Item No. **Report of the Interim Director of Planning, Regeneration & Public Realm**

Address 132 NORTHWOOD WAY NORTHWOOD

Development: Erection of a part single, part double front extension and a single storey rear extension with a raised patio

LBH Ref Nos: **12133/APP/2022/1824**

Ground floor front extension

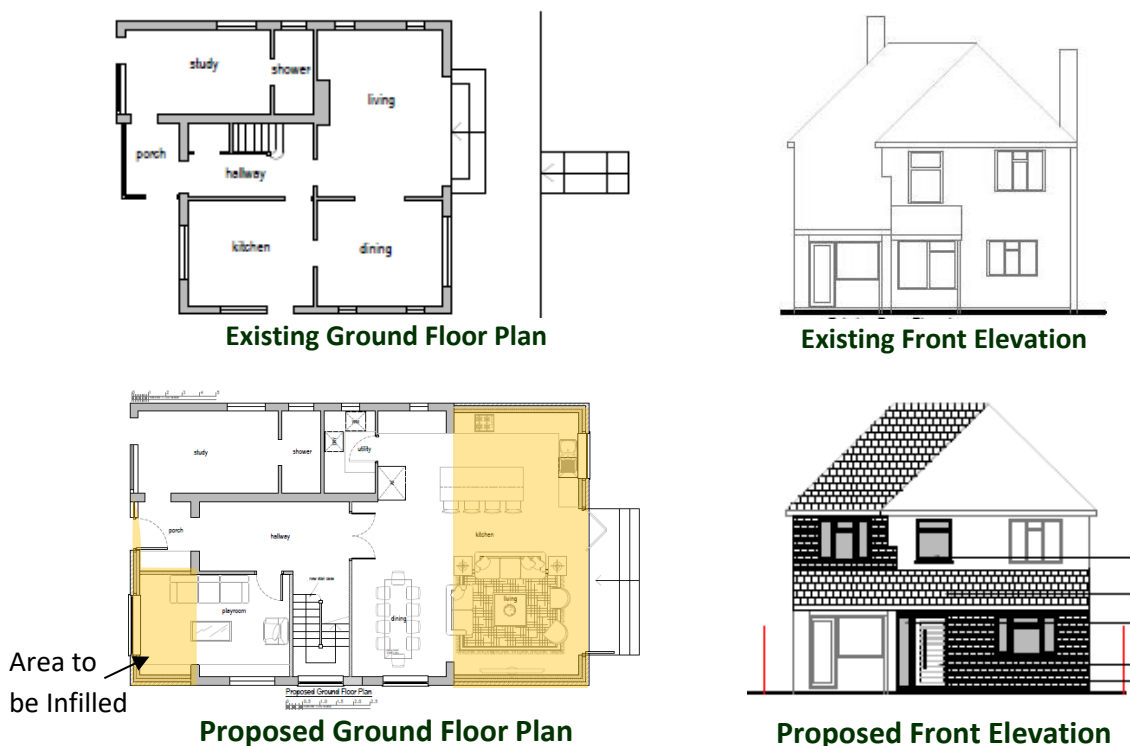
As per Policy DMHD 1 of the Hillingdon Local Plan: Part Two - Development Management Policies (2020) alterations and extensions to the front of a house must be minor and not alter the overall appearance of the house or dominate the character of the street. Furthermore, front extensions extending across the entire frontage will be refused. The proposal fails to comply with this policy and proportionally the extensions are not subordinate. In addition, the part two storey front extension would result in a large crown roof which would not be an example of good, contextual design and out of character with the surrounding properties.

The proposed front extensions by reason of its size, scale, bulk, projection and design would result in an incongruous and visually intrusive form of development that could not be considered to constitute subordinate additions to the existing dwellinghouse and the works would fail to respect the architectural composition of the existing dwellinghouse resulting in a detrimental impact on the character and appearance of Blaydon Close. The proposal would therefore be contrary to Policy BE1 of the Hillingdon Local Plan: Part One - Strategic Policies (2012), Policies DMHB 11, DMHB 12 and DMHD 1 of the Hillingdon Local Plan: Part Two- Development Management Policies (2020) and Chapter 12 of the National Planning Policy Framework (2021).

Approved Side Elevation

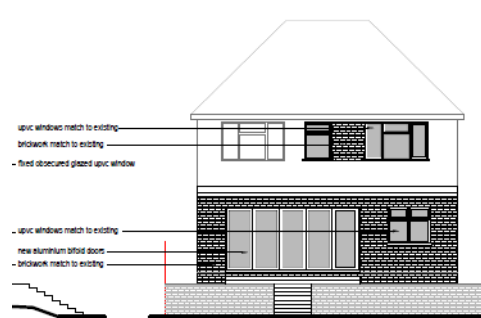
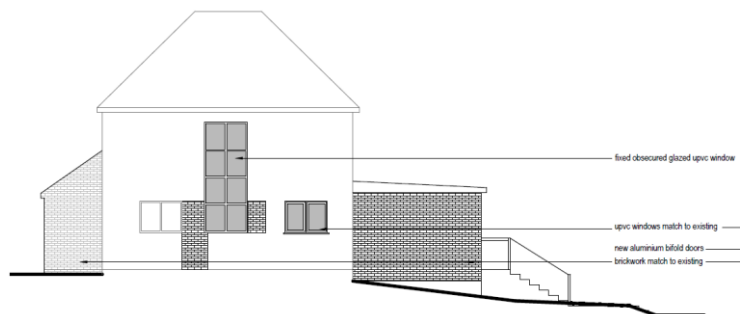
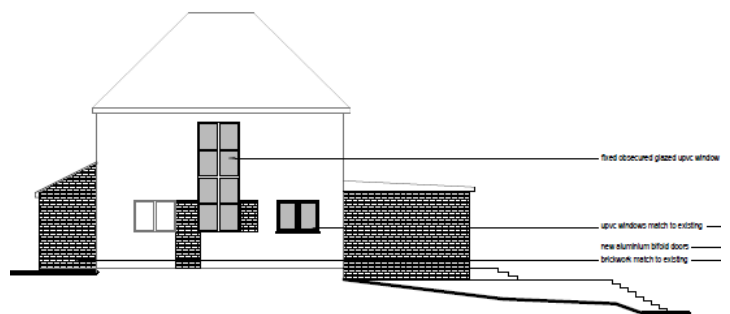
The ground levels are different on each property, falling at the rear. This design will create a platform which would project over 6m past the 4m deep rear extension. In relation to the boundary treatment and ground levels it would enable undue overlooking onto the neighbouring gardens and rear elevations at Number 130 and 134 Northwood Way.

The proposed rear steps and terrace development by reason of its size, scale, projection, siting and proximity to the shared boundary would result in undue overlooking which would have a direct impact on the amenities of 130 and 134 Northwood Way, resulting in a harmful loss of privacy, all contrary to the aims and requirements of Policy DMHB11 and DMHD1 of the Hillingdon Local Plan - Part Two (2020).
